DRB Application No.: 04DRB-00756
Project Name: JOURNAL CENTER 2, UNIT 1
Agent: Dorman & Breen Architects

13. **Project # 1003447**
04DRB-00756 Major-SiteDev Plan
BldPermit
- DORMAN & BREEN ARCHITECTS agent(s) for THE CHAPMAN COMPANIES, INC. request(s) the above action(s) for all or a portion of Lot(s) 11A, **JOURNAL CENTER 2, UNIT 1**, zoned IP industrial park zone, located on WASHINGTON ST NE, between WOLCOTT AVE. NE and MASTHEAD ST. NE containing approximately 1 acre(s). [REF: 1000633] (D-17) **SITE PLAN FOR BUILDING PERMIT WAS APPROVED WITH FINAL SIGN OFF DELEGATED TO PLANNING FOR PERIMETER WALL DESIGN AND ZHE QUESTION ON WALL HEIGHT VARIANCE.**

Project # 1003447
 04DRB-00756 Major-SiteDev Plan
 BldPermit

SITE PLAN
SCALE: 1" = 20'

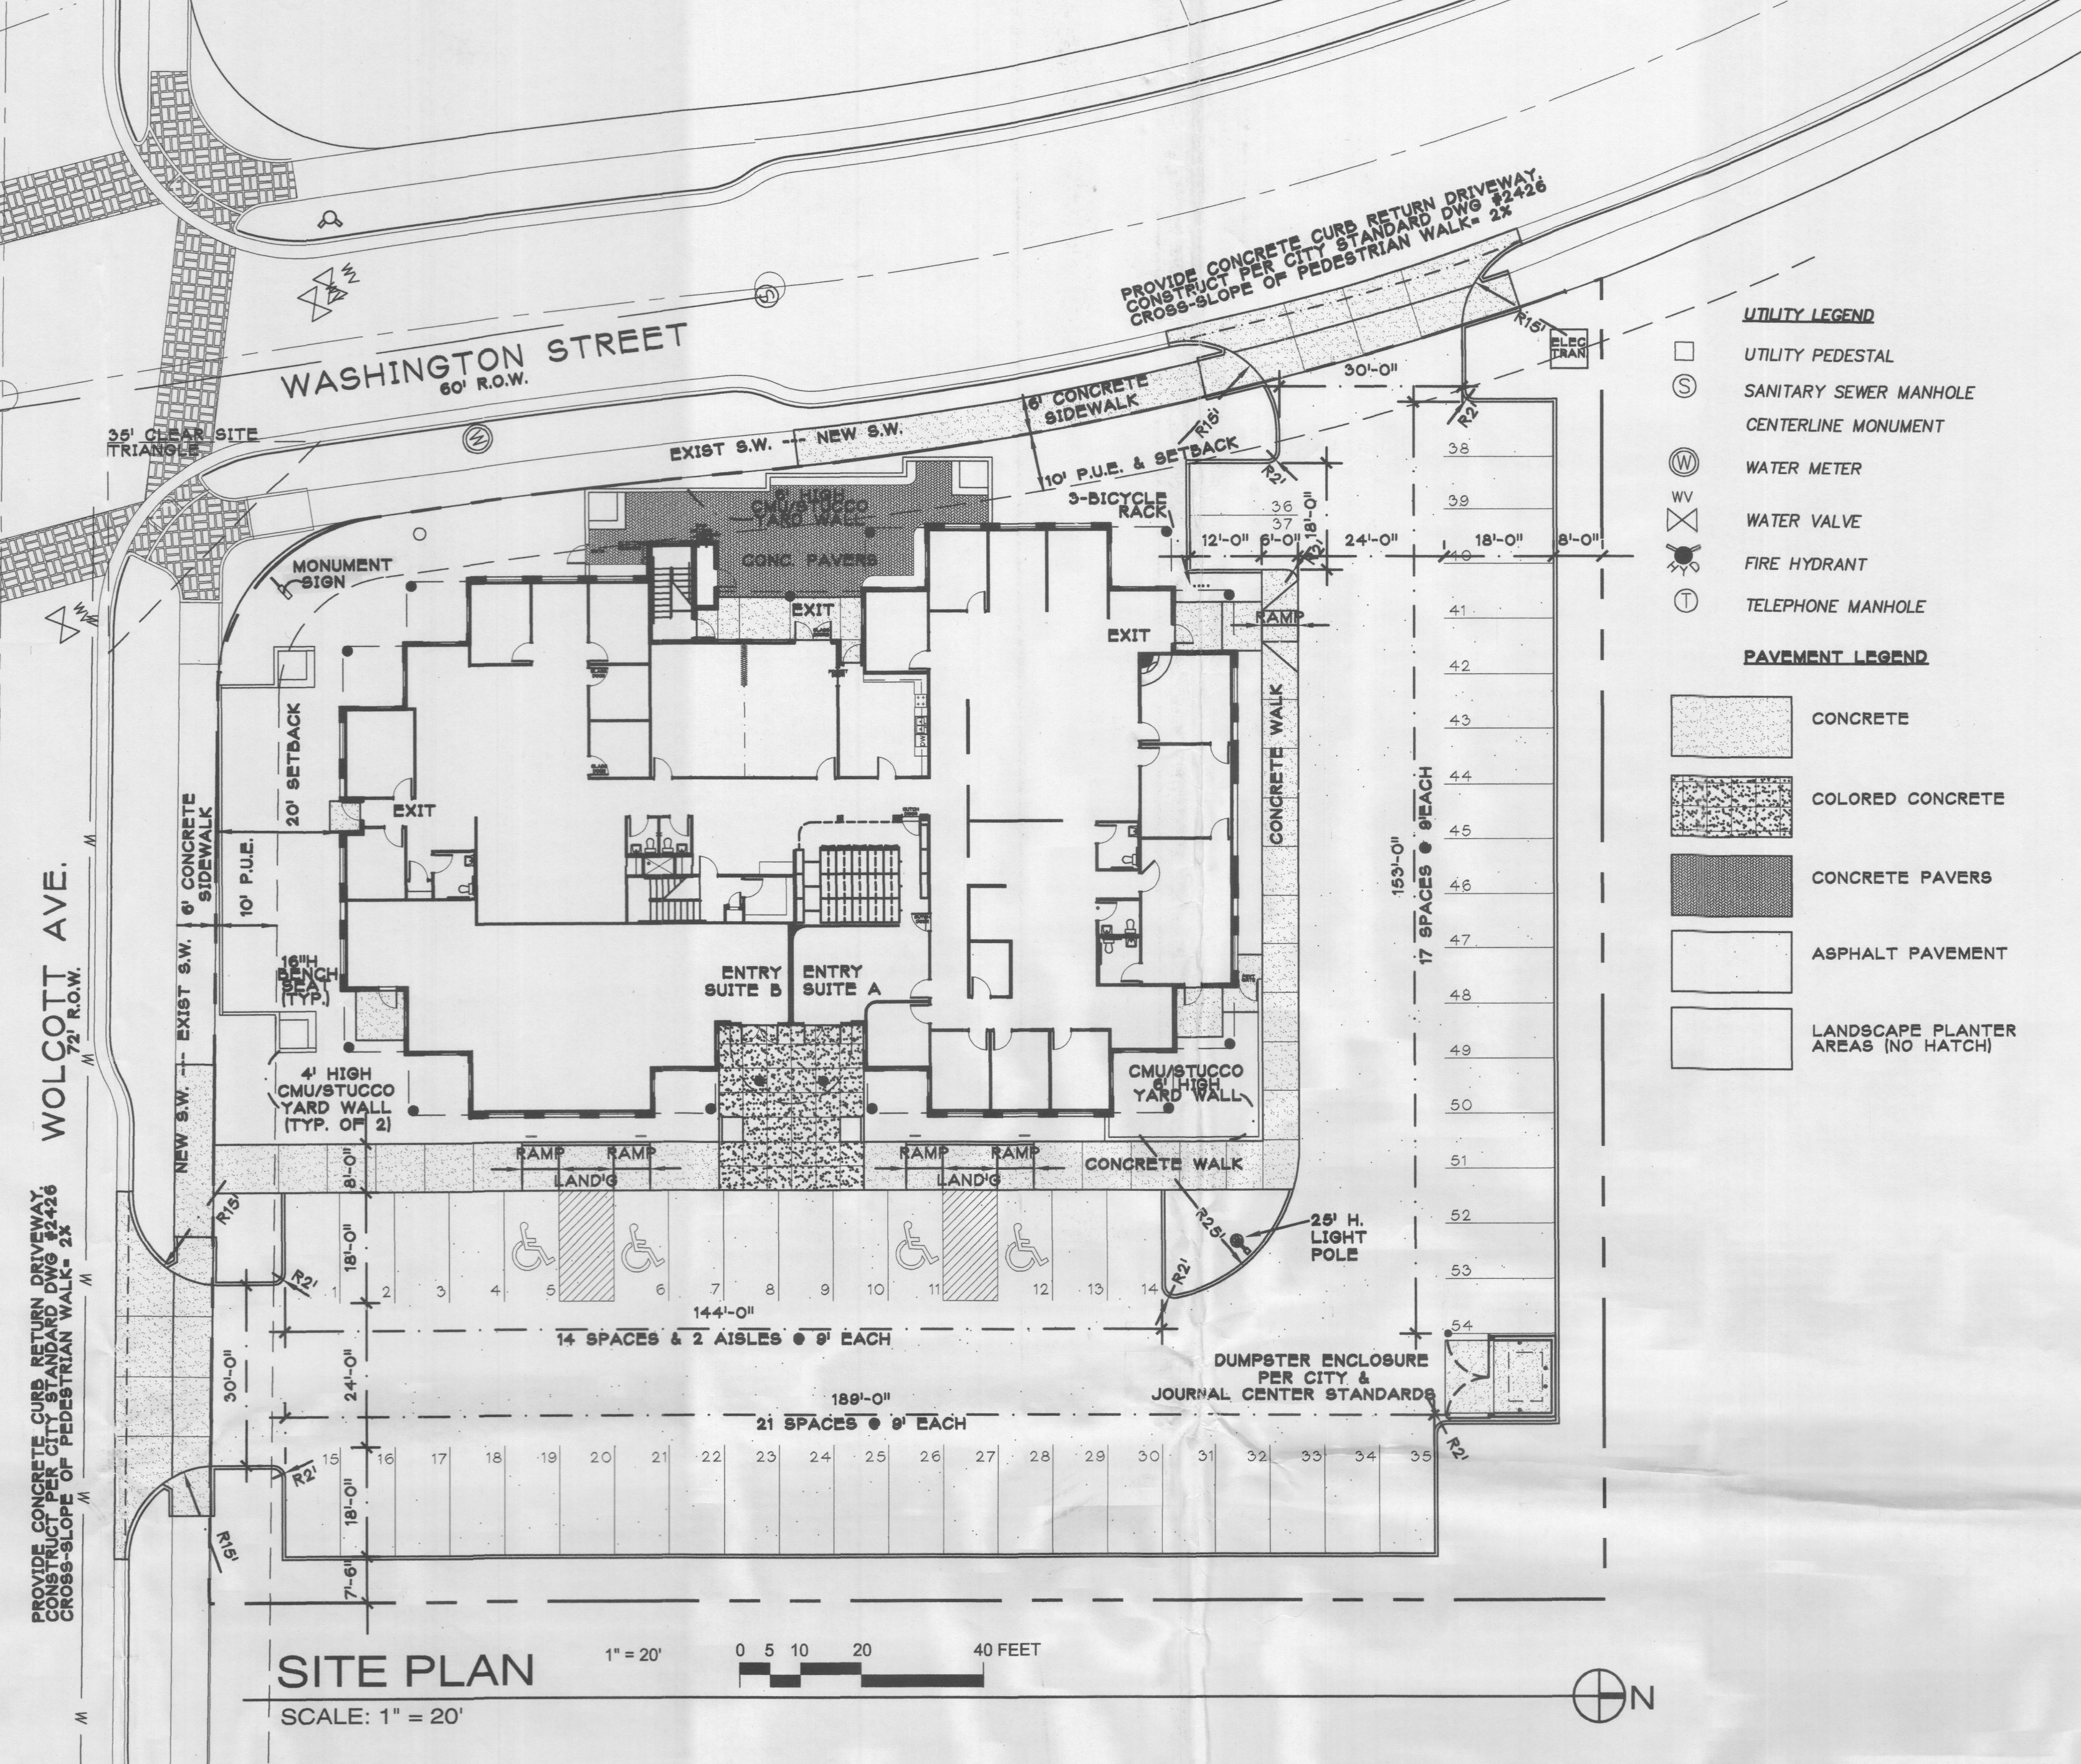
The site plan sheet with the signature block should be the first sheet on the SPBP submittal.

Site lighting on pole: Indicate height & fixture type.

The CMU/stucco yard walls identified along Washington & Wolcott need a perimeter wall design approval per the City Zoning Code. Please prepare 3 copies complying with the submittal requirements & Zone Code requirements.

SHEET TITLE
BUILDING ELEVATIONS

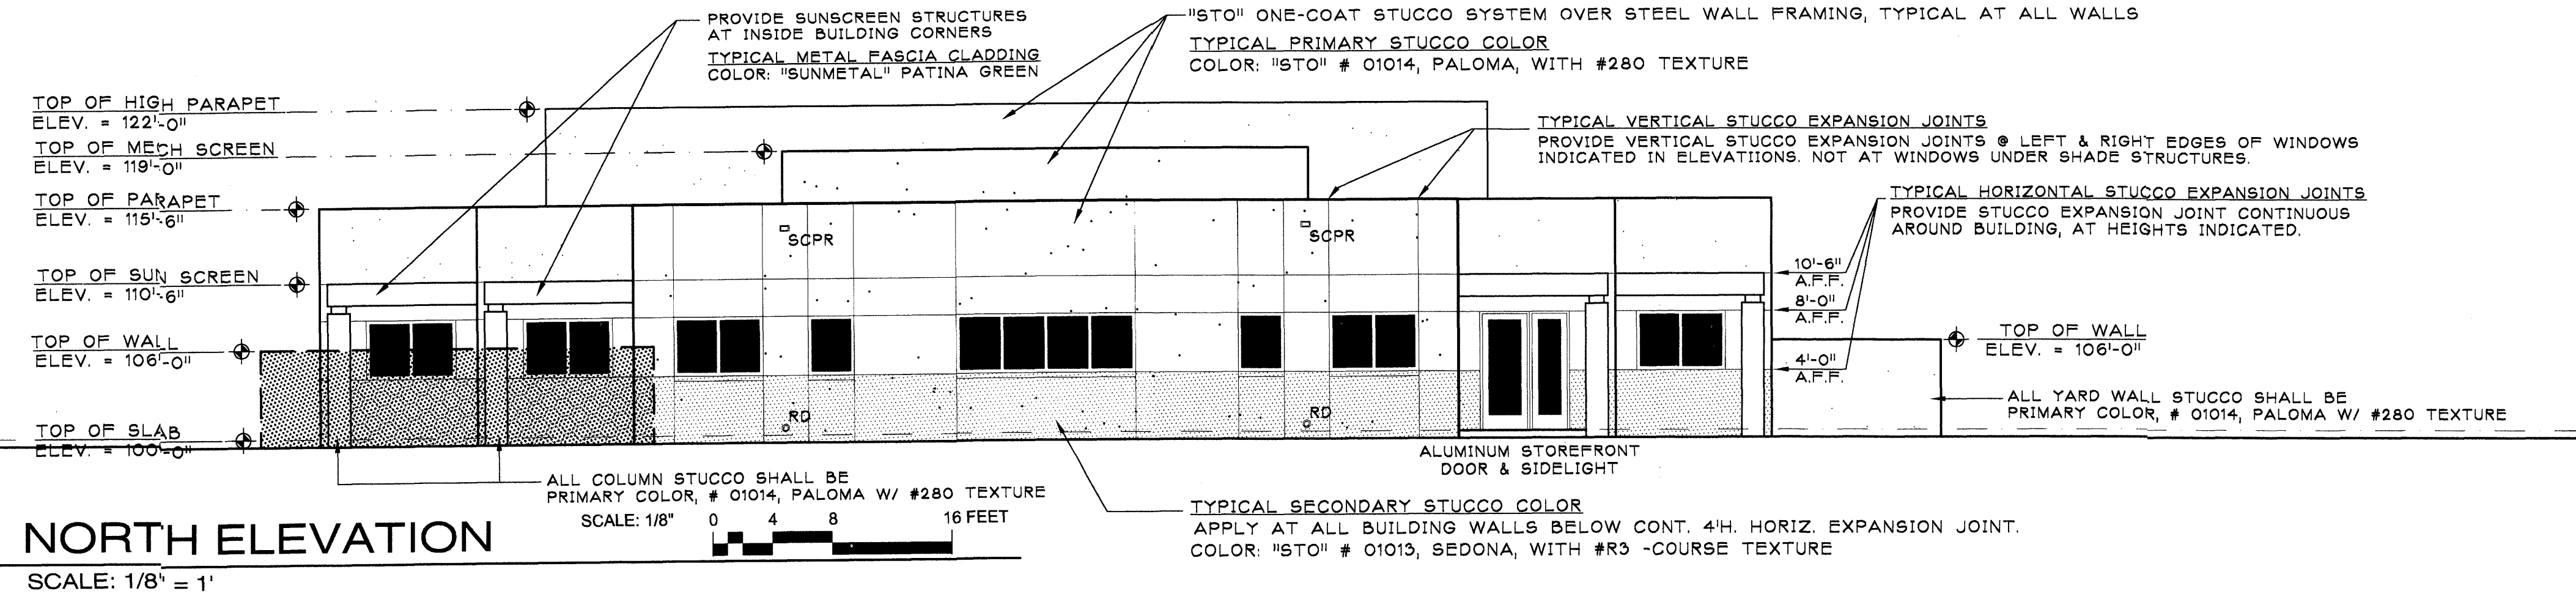
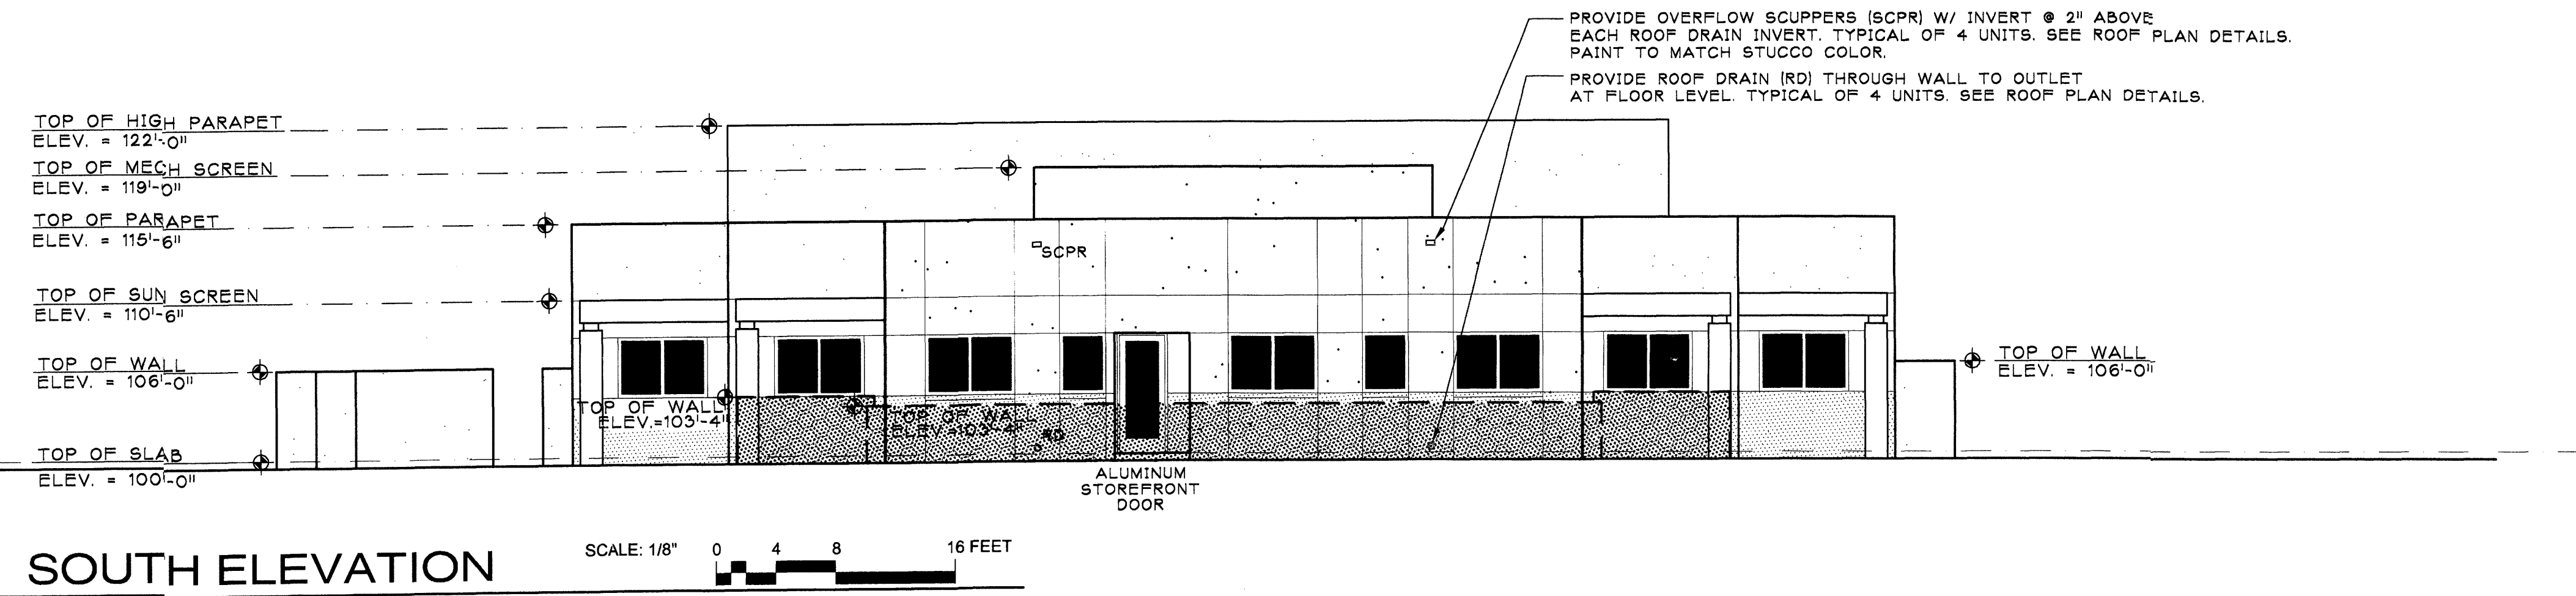
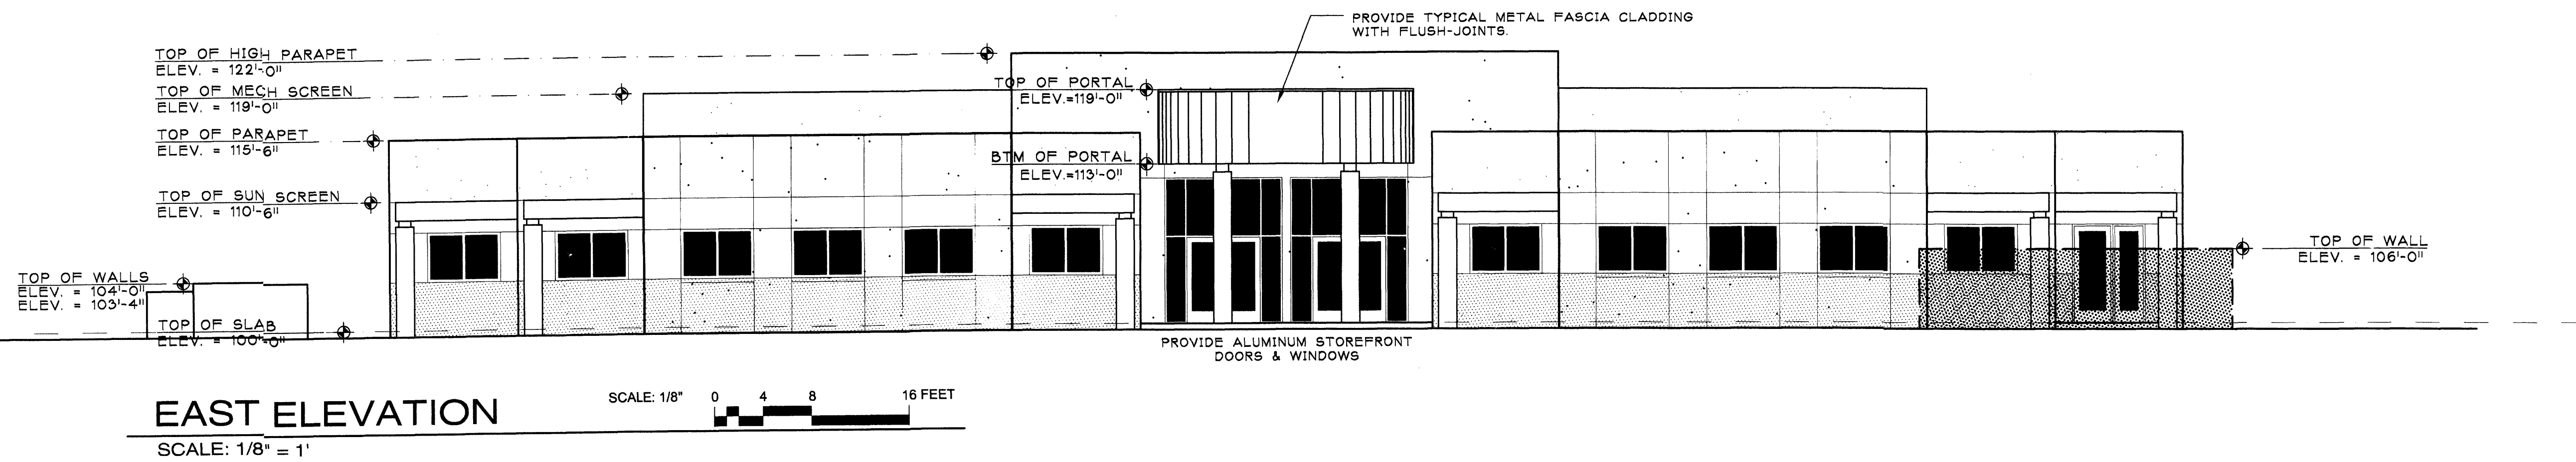
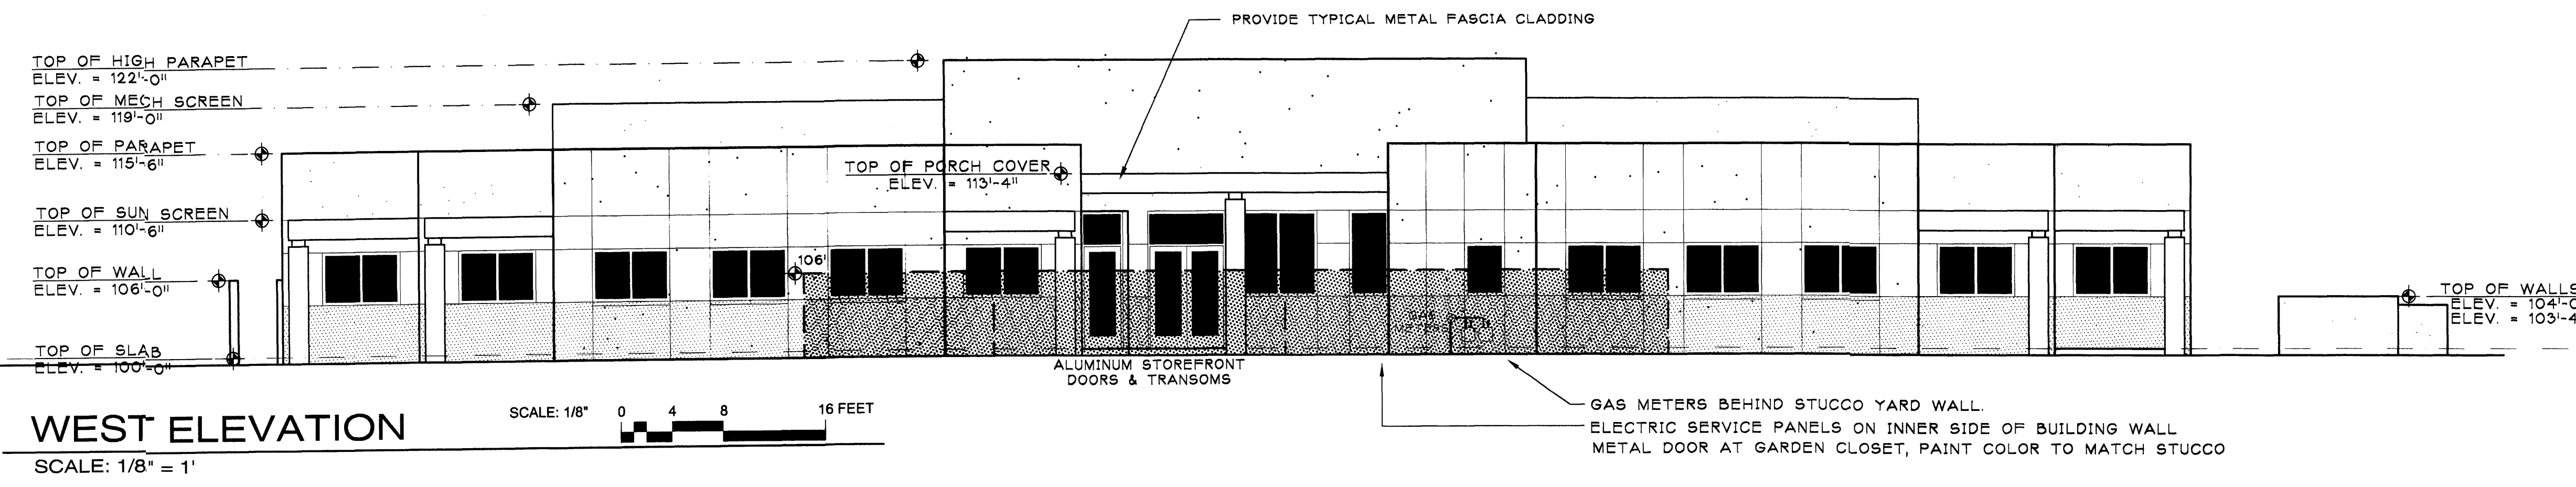
Figure 9 Journal Center 2 Monument Sign should be placed on one of the site plan sheets. There seems to be room on the Building Elevations Sheet.

The building elevations appear to be missing the total length dimensions.
